Application No: FG/184/21/PL
Site Address: 1 Greenways Crescent Ferring BN12 5EF
Description of works: Erection of replacement dwelling and garage

Thank you for your internet representation made on 3rd December 2021 which has been recorded as an objection with the comments as follows:

Figure 4: Existing and proposed north elevations

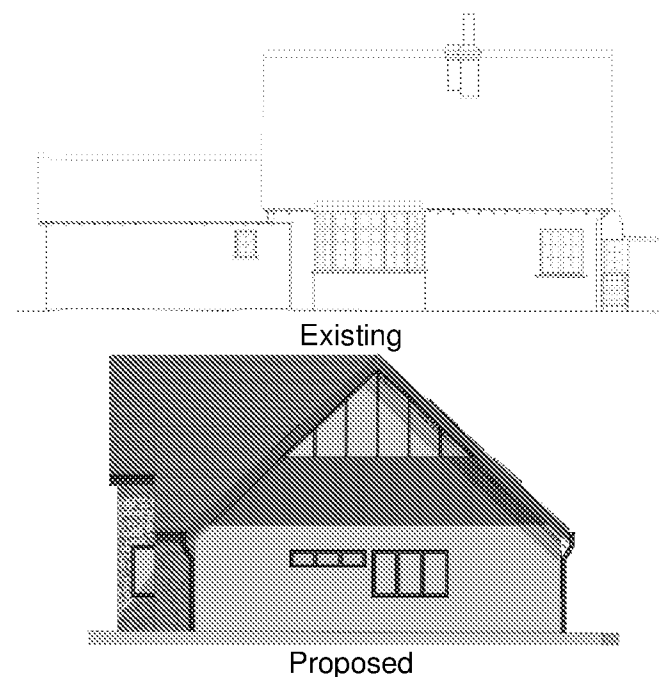
The proposed northern elevation of the new property will be considerably closer to the road than the existing house and we suggest this is undesirable because Greenways Crescent has grass verges instead of pavements and as we understand it, all the residents of the Crescent have a pedestrian right of way over the grass verges, including over the verge at Number 1. If so, the north facing elevation of the new house would be extremely close to that pedestrian verge.

The prominent position of the northern elevation of the new house would be inconsistent with the position of the established properties at Nos.2,3,4,5,6,7,8,9 and 10 Greenways Crescent, which are all set well back from the road. In our view, the new house with a vertical elevation, replacing the existing sloping elevation, and closer to the road will be a carbuncle in the close.

In our view, the huge glass windows on the northern elevation of the new house will be intrusive to the overlooked properties on the northern side of the close.
